Re: AB/14/21/HH - Riverside House, 2 Fitzalan Road, Arundel, BN18 9JS

We are instructed on behalf of the 4 owners in Otters Quay, Arundel in relation to an application (AB/14/21/HH) at Riverside House, 2 Fitzalan Road, Arundel, for the Reinstatement of timber jetty using existing 3 piles adjoining the property.

JETTY
PROPOSED SITE LAYOUT

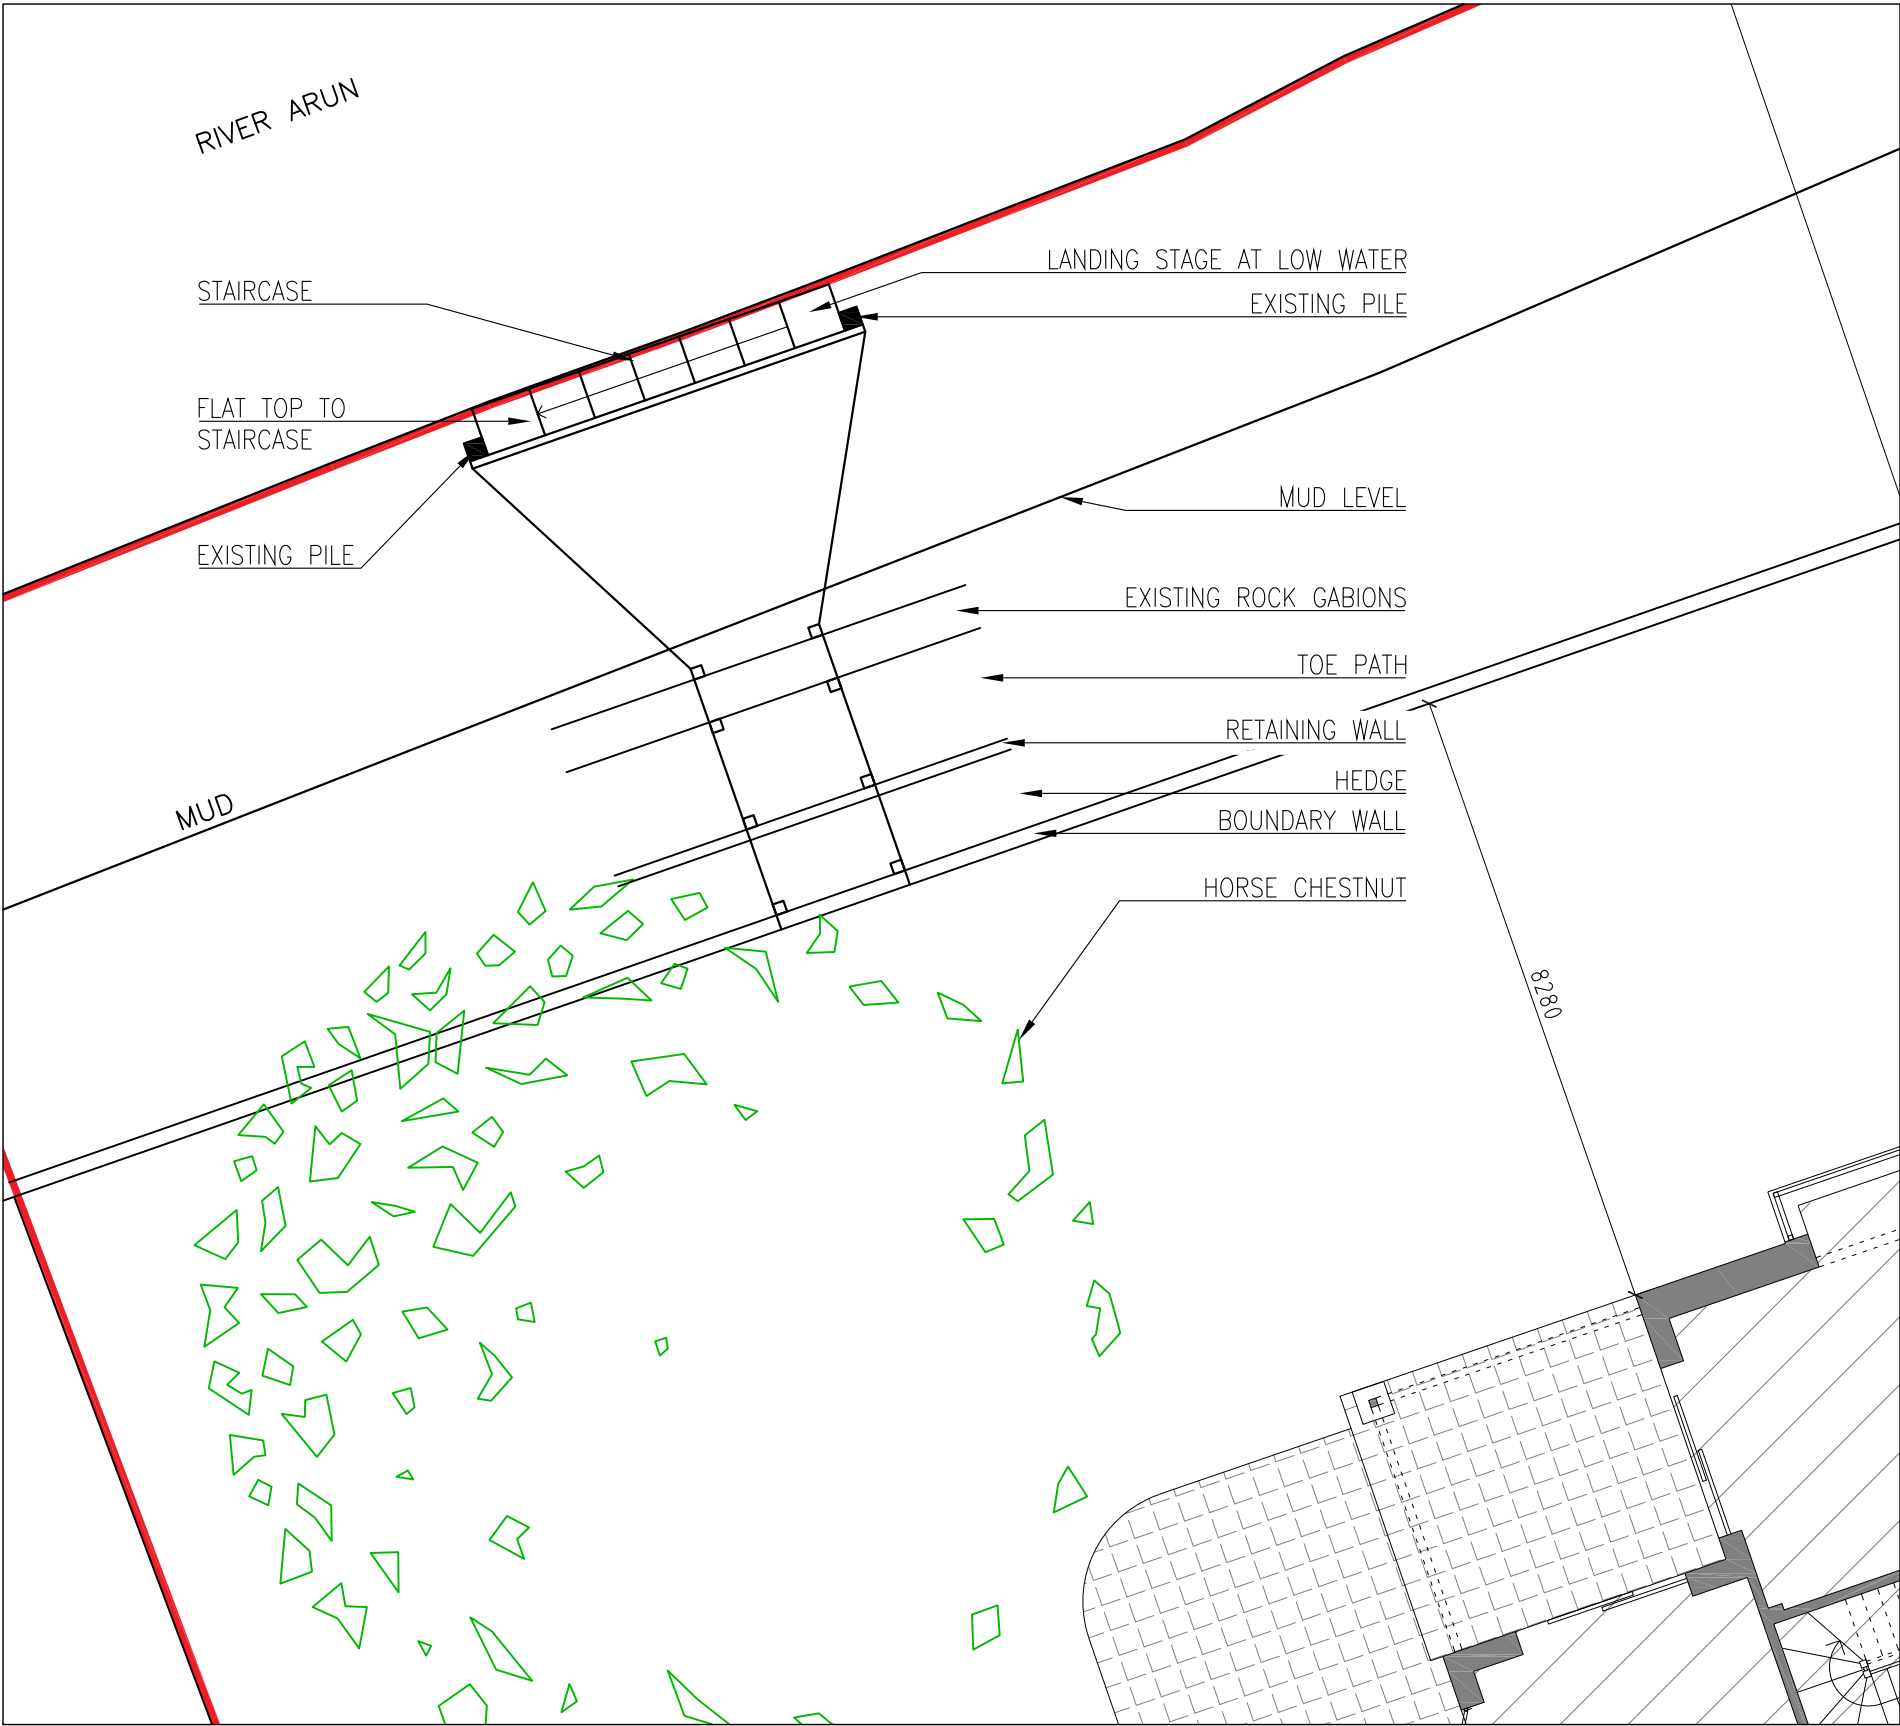
As has been set out above the bankside area is a quiet undisturbed riverside zone, and of considerable habitat value. The former mooring areas have over the years been removed to create what is in essence a bankside meadow area, and this would be disrupted by the proposed development.

Policy S-CC-4 states that “*proposals that may have a significant adverse impact on habitats that provide a flood defence...*” Due to the close proximity of the development proposals to the existing flood defences which would be situated to the south, the scheme would likely result in an adverse impact on the adjacent habitat, which could ultimately lead to worsening the issues relating flooding.

JETTY
PROPOSED EAST AND WEST ELEVATIONS

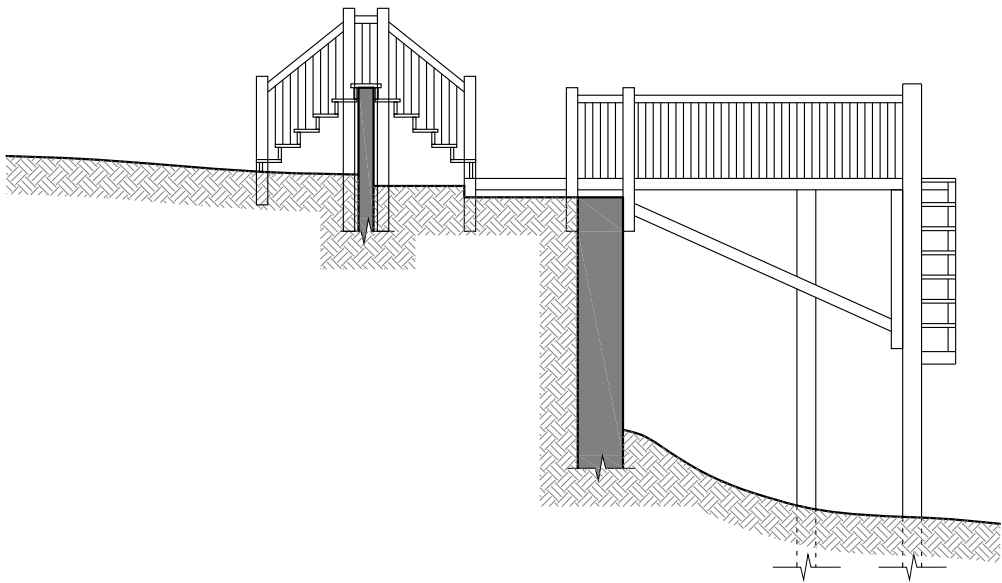
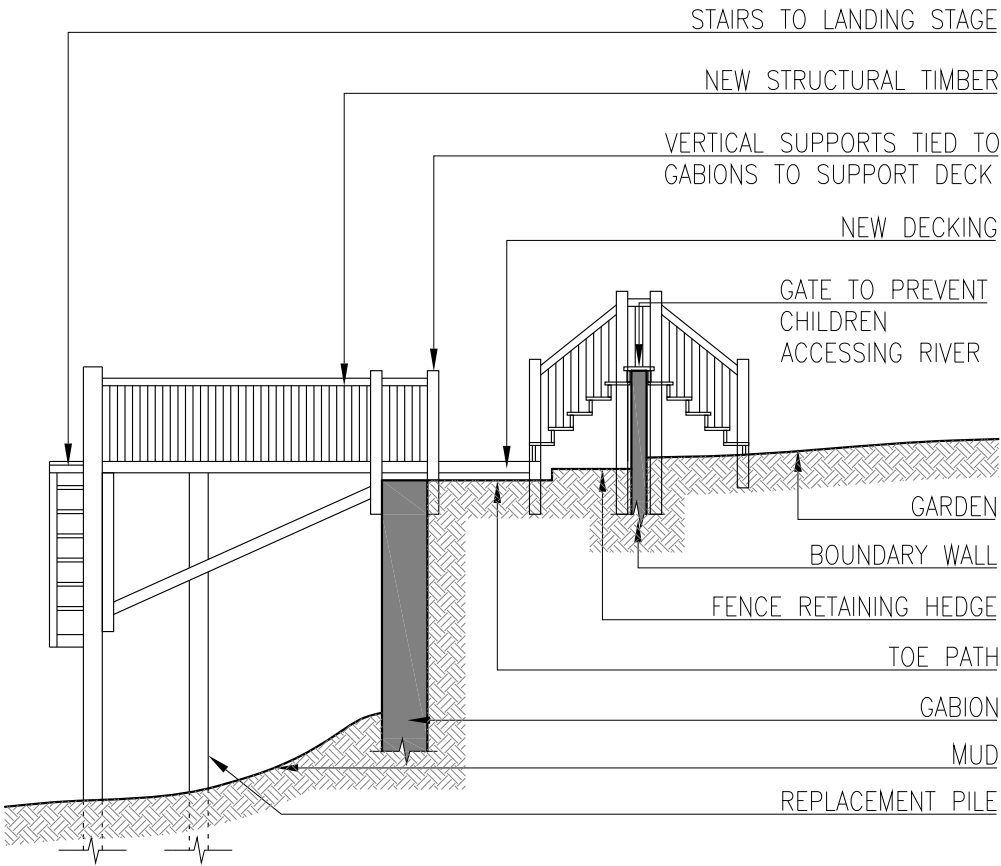
Policy D DM1 requires development to “*have minimal impact to users and occupiers of nearby property and land.*” As has been previously set out the development proposals will lead not just to a significant visual impact, owing to its proposed height, but also to overlooking and privacy loss. This will lead to a significant loss of amenity and our clients ability to experience the quiet enjoyment of their properties. This would be contrary to Policy QE SP1 which requires that “*all development contributes positively to the quality of the environment and will ensure that development does not have a significantly negative impact upon residential amenity...*”

Policy S-CO-1 sets out that “*proposals will minimise their use of space and consider opportunities for co-existence with other activities.*” Given the overbearing nature of the proposal and its scale the proposal is in conflict with policy.
